**CITY OF MERCER ISLAND**

**CRITICAL AREA DETERMINATION**

**NOTICE OF DECISION**

<b>Project Number:</b>	CAO19-006
<b>Description:</b>	A request for a Critical Areas Determination (MICC 19.07.070(B)). The proposal is to reduce a piped watercourse buffer to allow construction of a new single-family residence after demolishing the existing residence. The buffer for the piped watercourse will be reduced from 25 feet to 10.75 feet at its narrowest point. 374 square feet of buffer will be reduced, and 375 square feet of buffer will be added.
<b>Applicant/ Owner:</b>	Richard A Fisher of RFA Architects/Steve and Sophy Yang
<b>Site Address:</b>	6660 E Mercer Way (a.k.a. 9640 SE 68 <sup>th</sup> St), Mercer Island, WA, 98040; Identified by King County Assessor tax parcel 239600-0050
<b>Zoning:</b>	R-8.4
<b>SEPA Compliance:</b>	This proposal is categorically exempt from SEPA review per WAC 197-11-800(b)(i).
<b>Exhibits:</b>	<ol style="list-style-type: none"><li>1. Development Application, dated received by the City on March 14, 2019.</li><li>2. Project plans prepared by The Watershed Company, dated received by the City on October 7, 2019.</li><li>3. Critical Area Study prepared by The Wate

MITIGATION PLAN

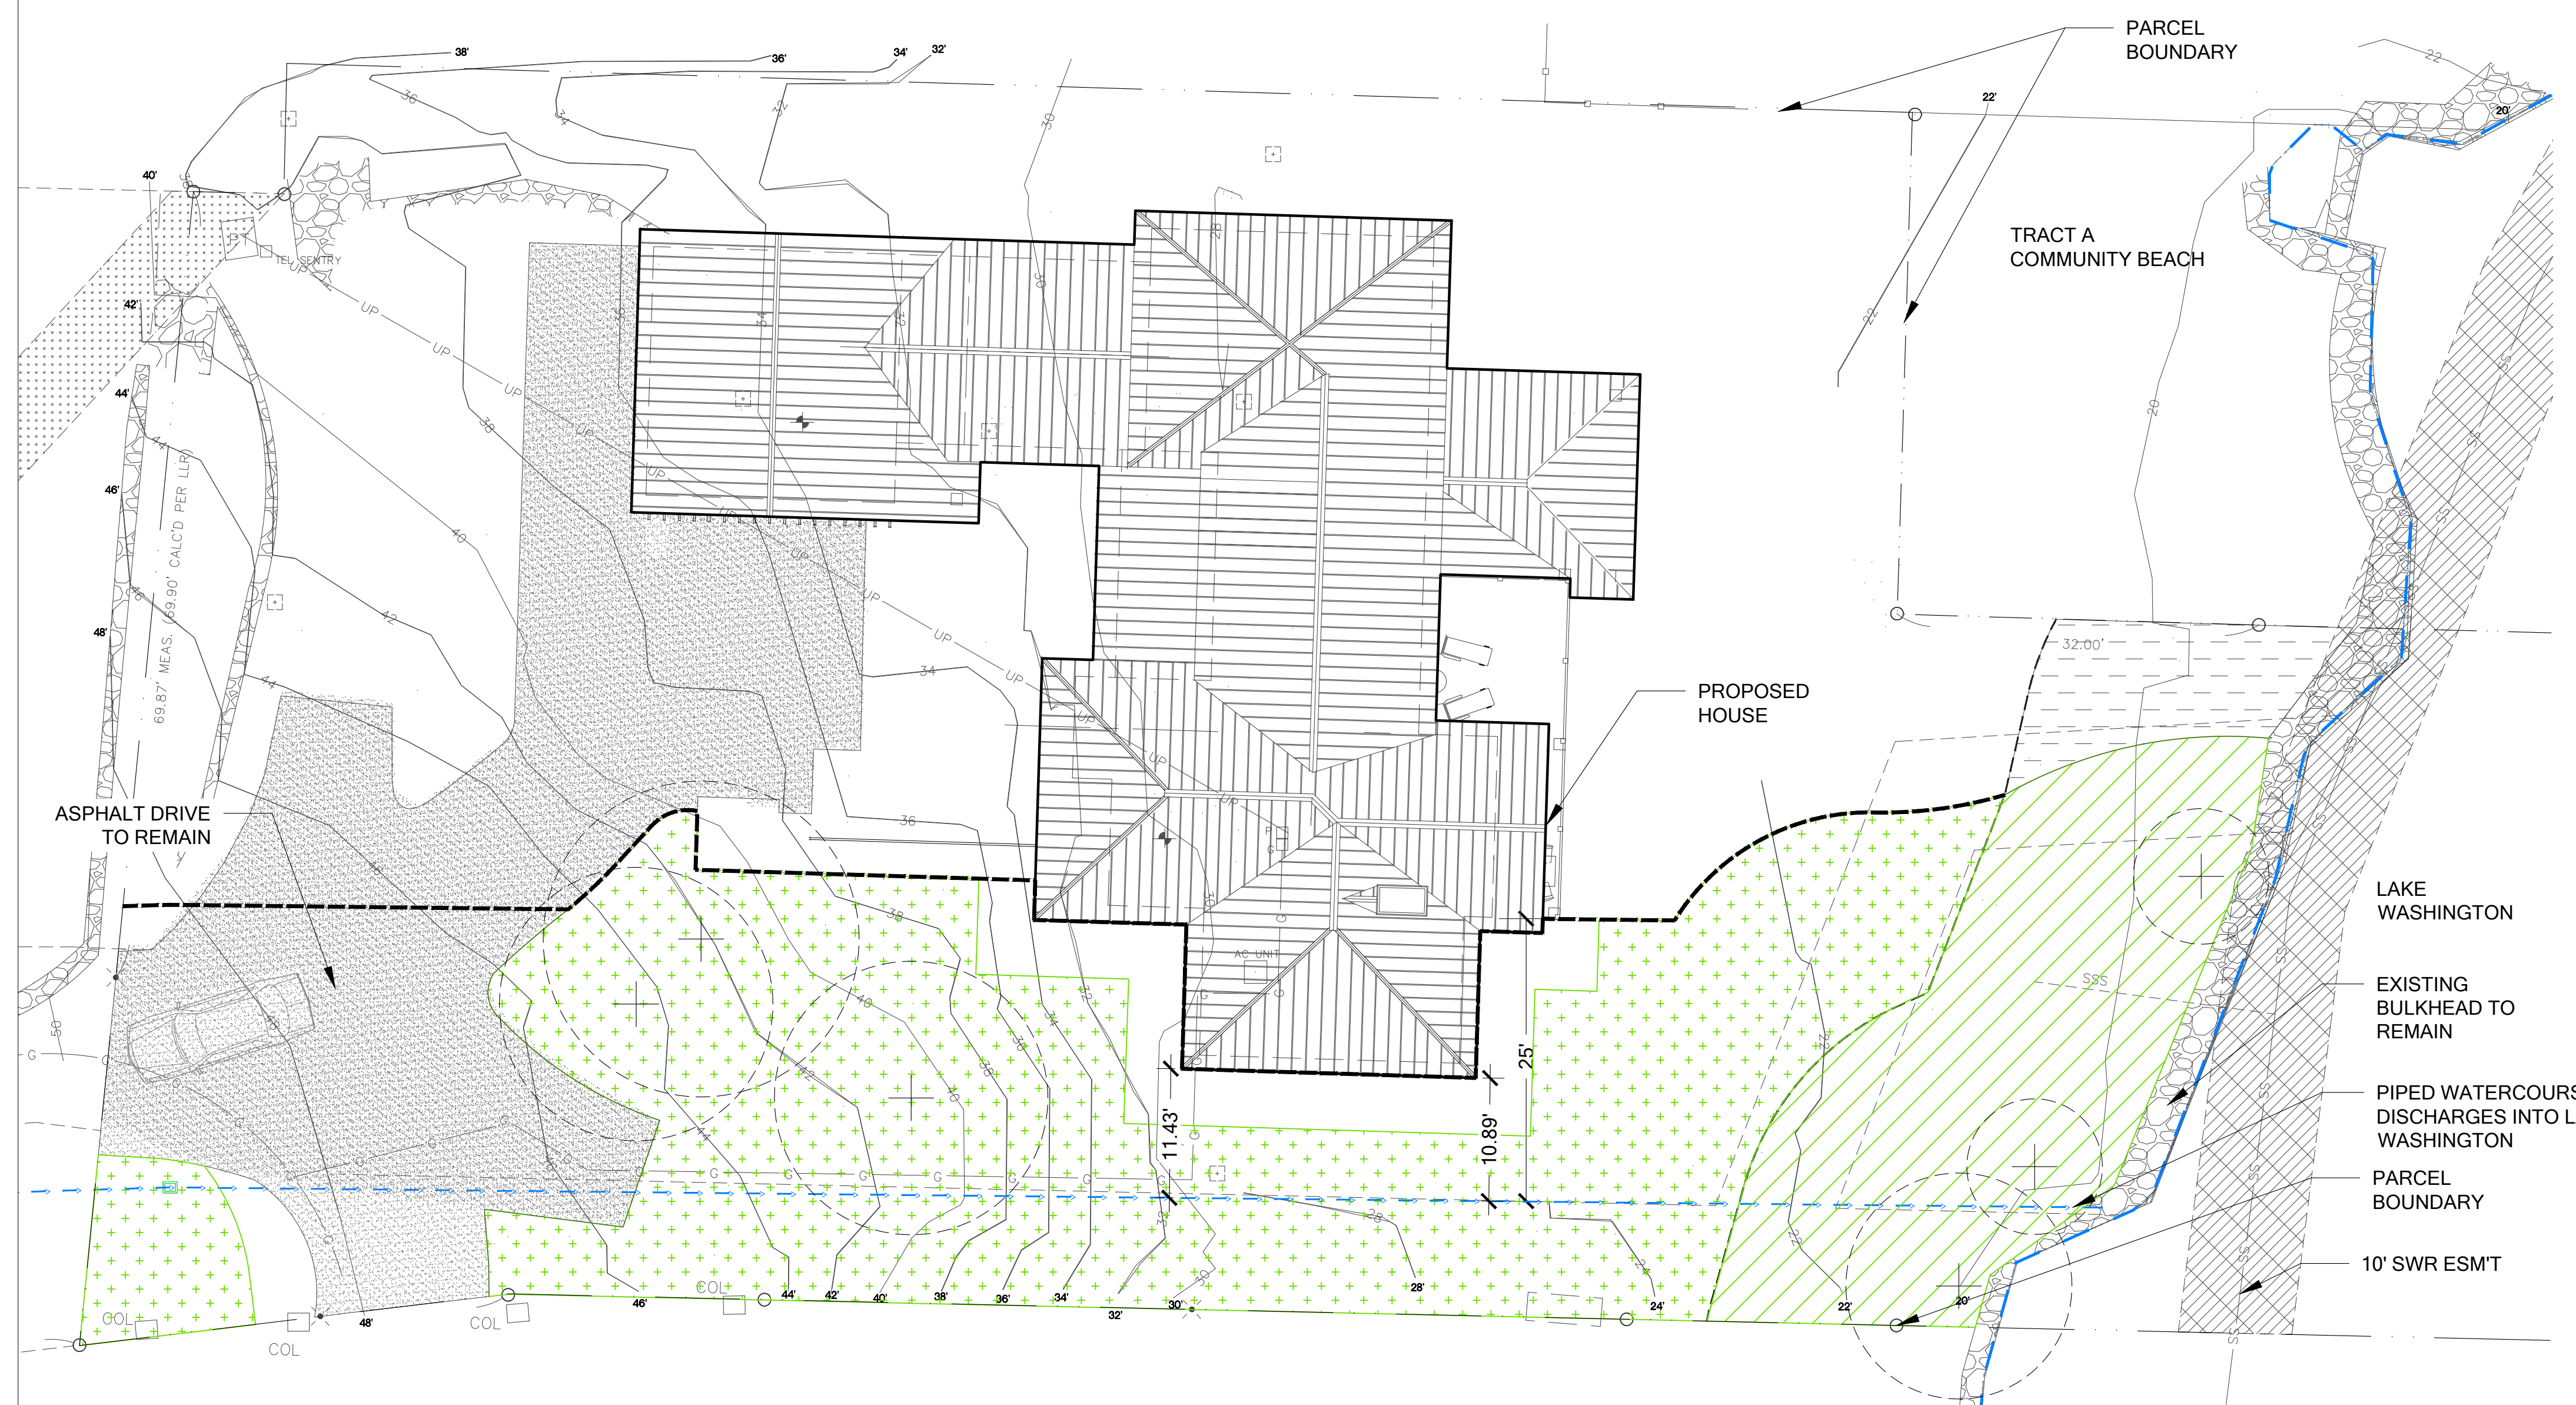
b. Three comments were received from the neighbors immediately to the south, Chris and Nicole Niederman (Exhibits 8.a and 8.b, 9, and 10). The comments related to both the Critical Area Determination and the associated building permit. The Niederman's expressed two primary concerns. One concern was about the width of the existing access road that provides access to the subject property. The other concern was that the original plans showed mitigation plantings in an area currently occupied by the Niederman's driveway where it crosses over the applicant's lot outside of the recorded access easement. Planting vegetation in that area would result in the Niederman's relocating their driveway.

The existing access road has been in place since the 1970's. Fire code does call for a 20-foot wide fire access roadway, and the existing access easement is only 10-feet wide. Because the road and its associated easement is existing, it can remain as 10-feet if the applicant includes code alternates to address the fire deficiency. The fire marshal will only approve their part of the review if they determine that the fire deficiency is alleviated by the code alternates. To address the concern that the mitigation plantings were proposed in the location of the neighbor's driveway, the applicant's relocated the proposed mitigation plantings away from the current location of the Niederman's driveway.

PROJECT MANAGER: RK
DESIGNED: RK/KMB/GM
DRAFTED: GM
CHECKED: RK/KMB
JOB NUMBER: 180605
SHEET NUMBER: **W5 OF 7**

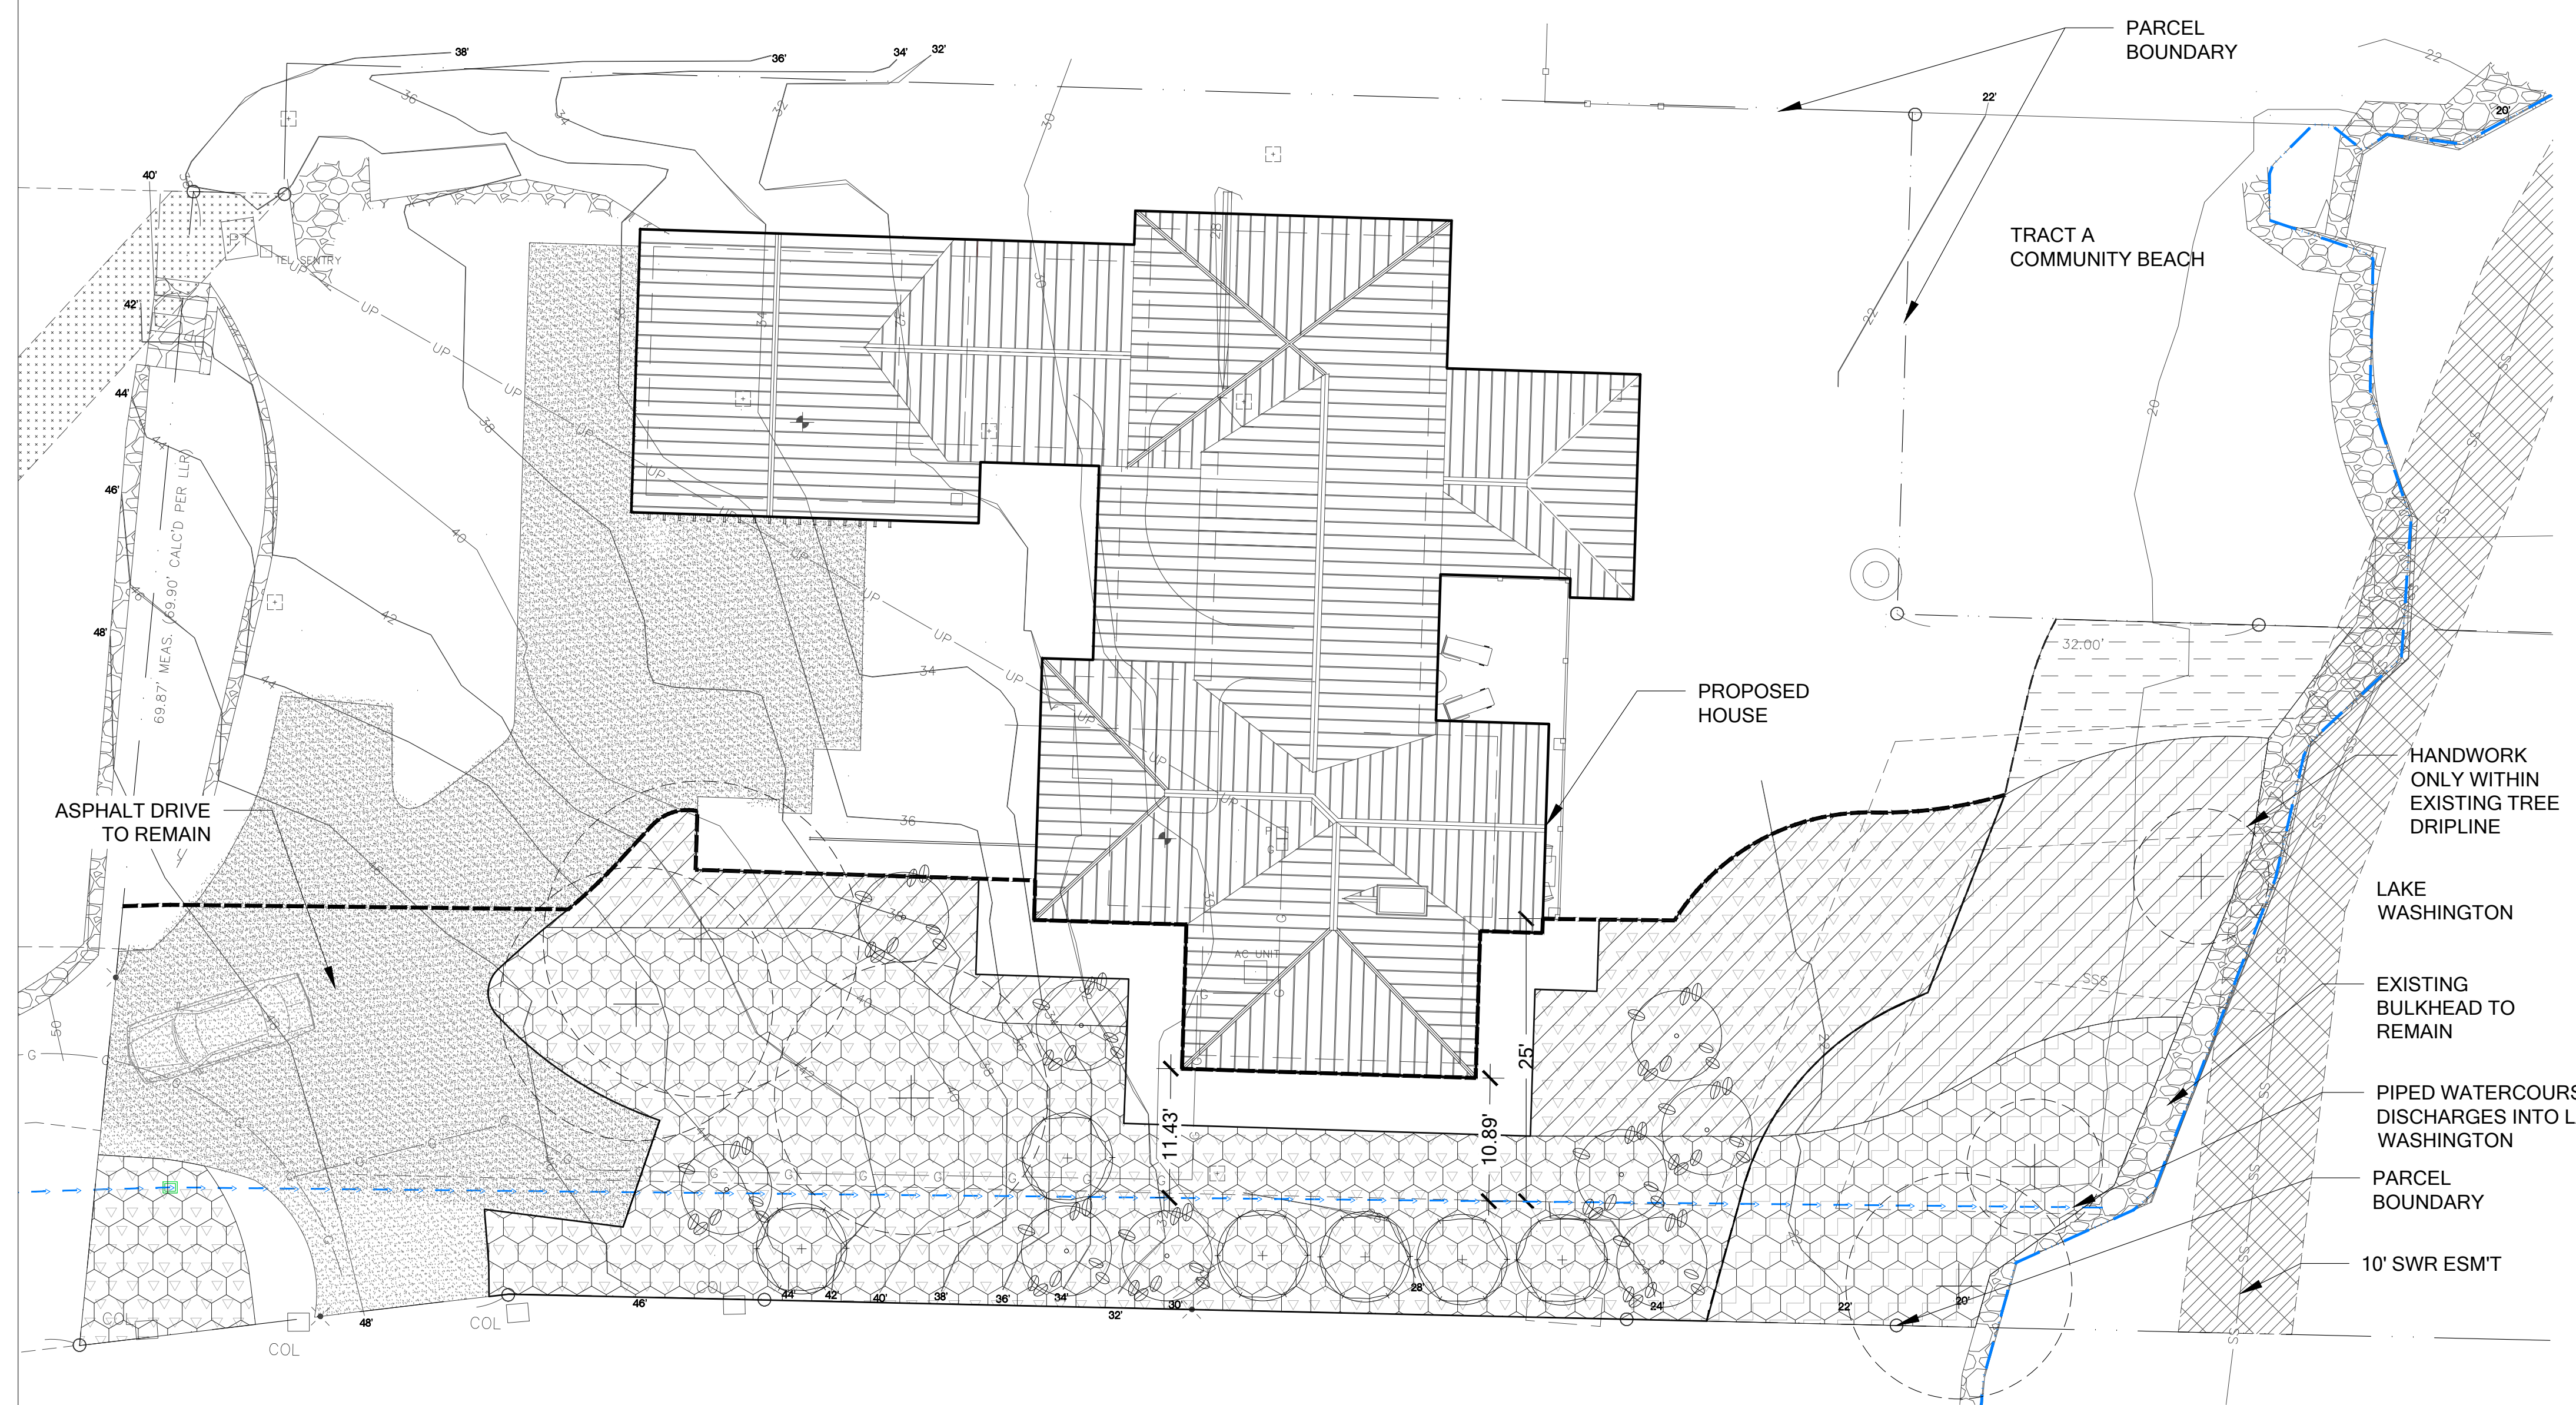
(2). The plans note a few existing trees (unidentified pine species) will be removed from areas adjacent to the piped stream and Lake Washington. The proposed critical areas planting plan

shows no new trees along the piped stream and planted areas Lake Washington. There should be trees planted to replace those removed or at least some native willows that will provide more habitat functions along the nearshore of Lake Washington than those shrub species proposed.

According to the City's GIS maps, this water source has been piped since at least 1963. The pipe is extremely deep, and daylighting of the watercourse is not practical. Due to the depth of the pipe, the outlet into the Lake is not visible and could not be located. It appears to extend far into the lake. All existing trees in the watercourse buffer will be preserved. Non-native shrubs will be removed. The replanting plan includes nine vine maples and six cascaras.
